Ribble Valley Borough Council
Housing & Development Control

Application no: **3/2022/1038**

Address: **Land at the corner of Moorgate Lane and Kenyon Lane Dinckley BB6 8AN**

Proposal: **Proposed development of a holiday cottage.**

Proposed Site Plan - 1:200

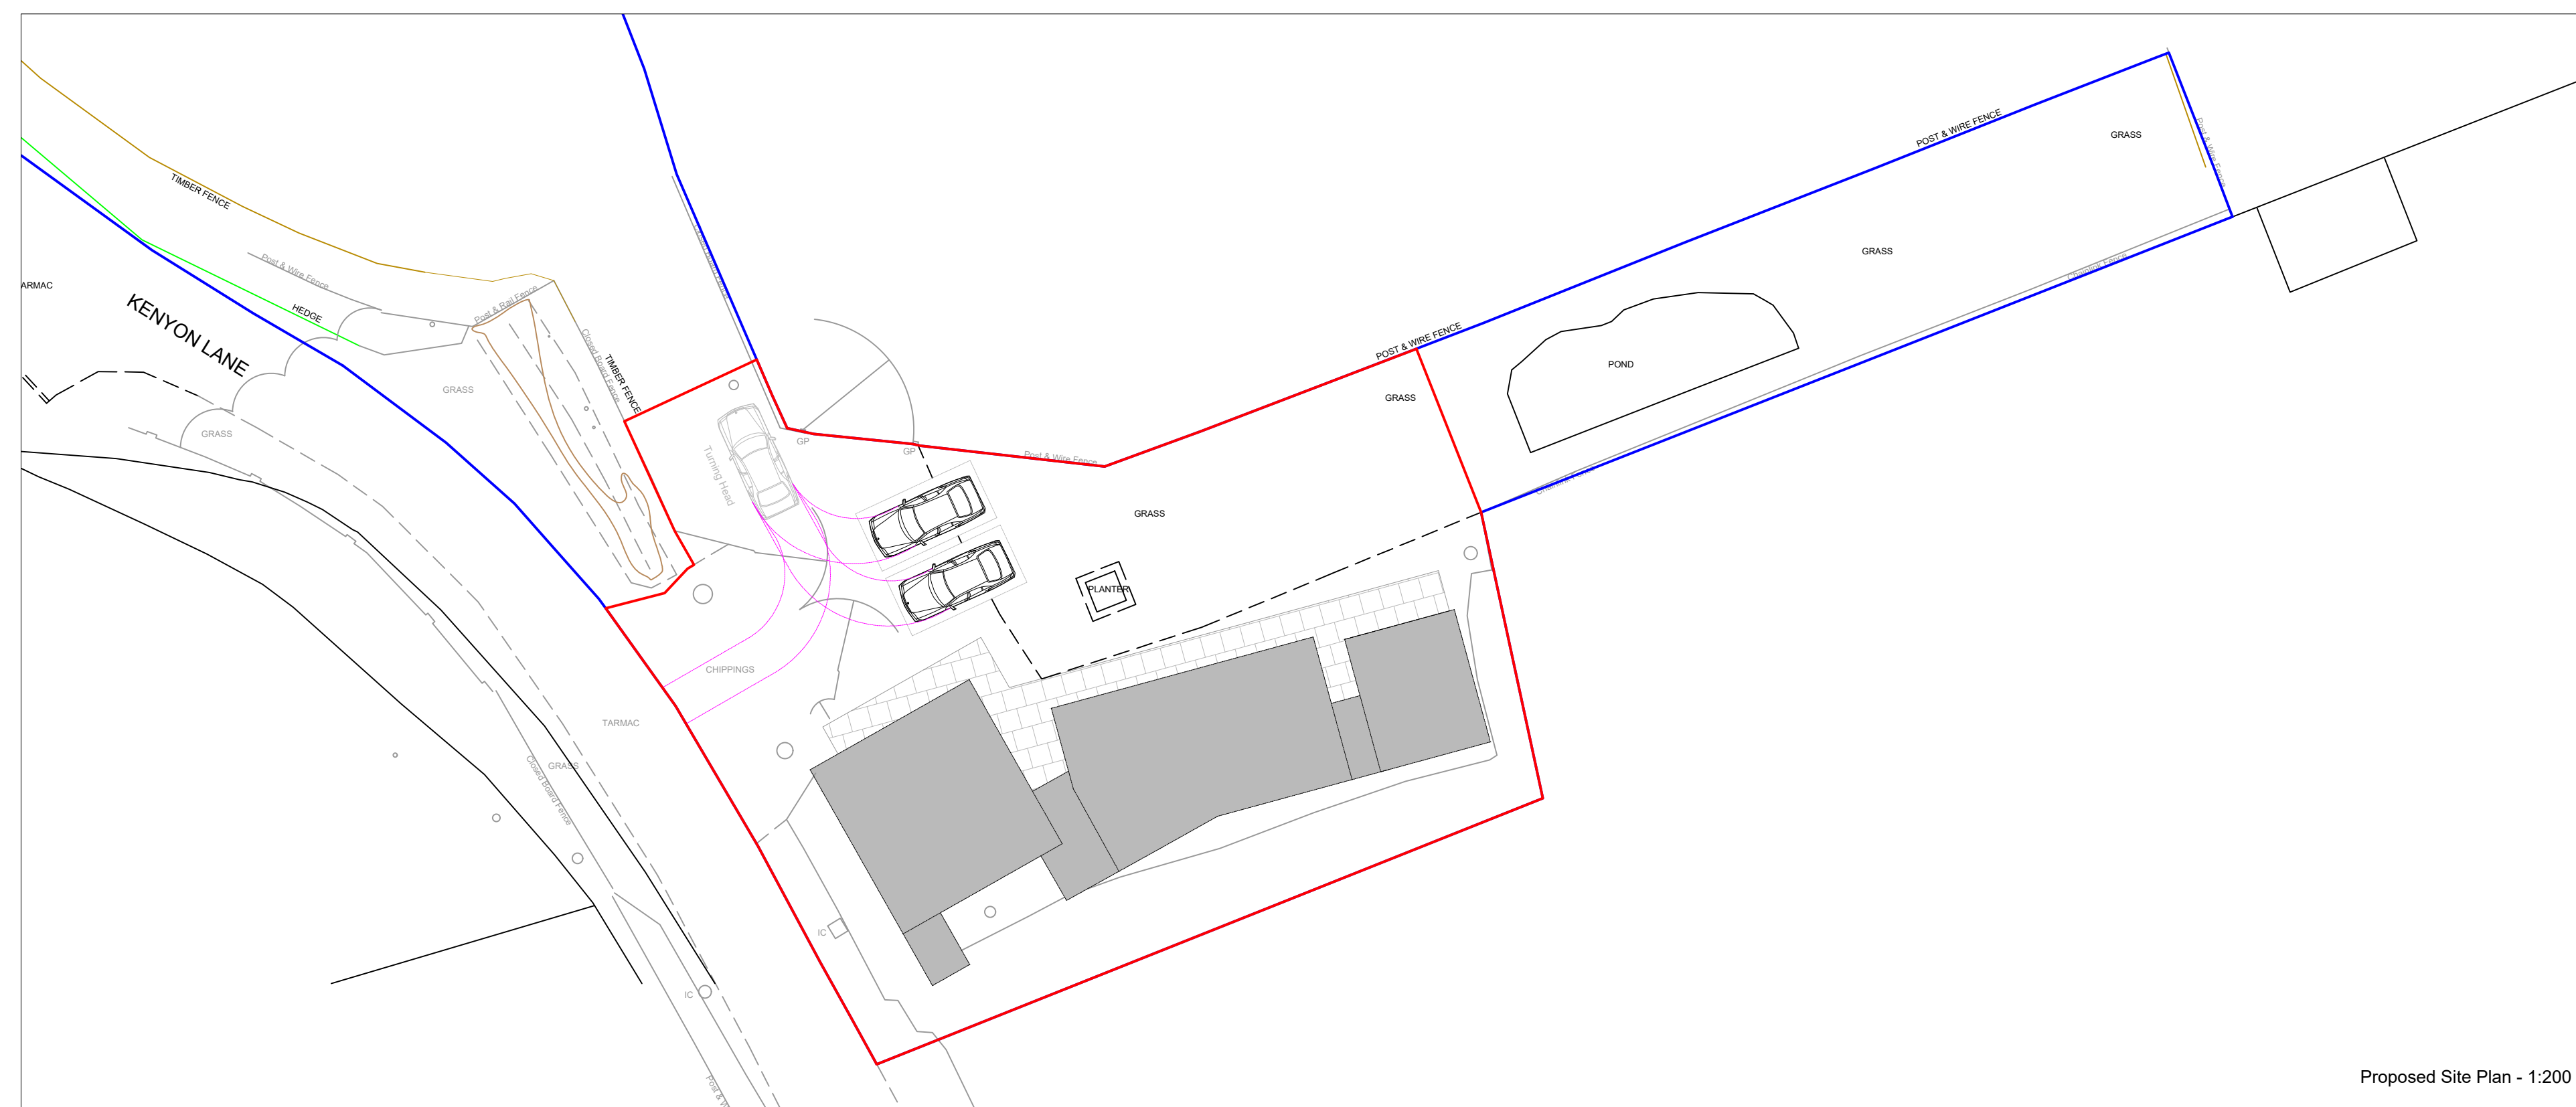
The LHA have reviewed GHA drawing number Shi.771.3237.02 titled "Proposed and Existing Site Plans. Proposed and Existing Plans and Elevations" and are aware that the proposed holiday cottage will utilise the same access which currently serves the allotment.

The LHA have reviewed GHA drawing number Shi.771.3237.02 titled "Proposed and Existing Site Plans. Proposed and Existing Plans and Elevations" and are aware that 2 car parking spaces can be provided for the 2-bed holiday cottage which complies with the LHAs parking standards as defined in the Joint Lancashire Structure Plan.

However, the LHA will condition that a new parking plan is submitted with there being inadequate turning facilities for vehicles to exit the site in a forward gear, which is important given the single-track nature of Kenyon Lane.

The LHA advise that the location of the parking spaces is altered to enable turning to occur internally.

5. The development hereby permitted shall not be occupied until such time as a parking plan for the site has been submitted to the Local Planning Authority, in consultation with the Local Highway Authority.
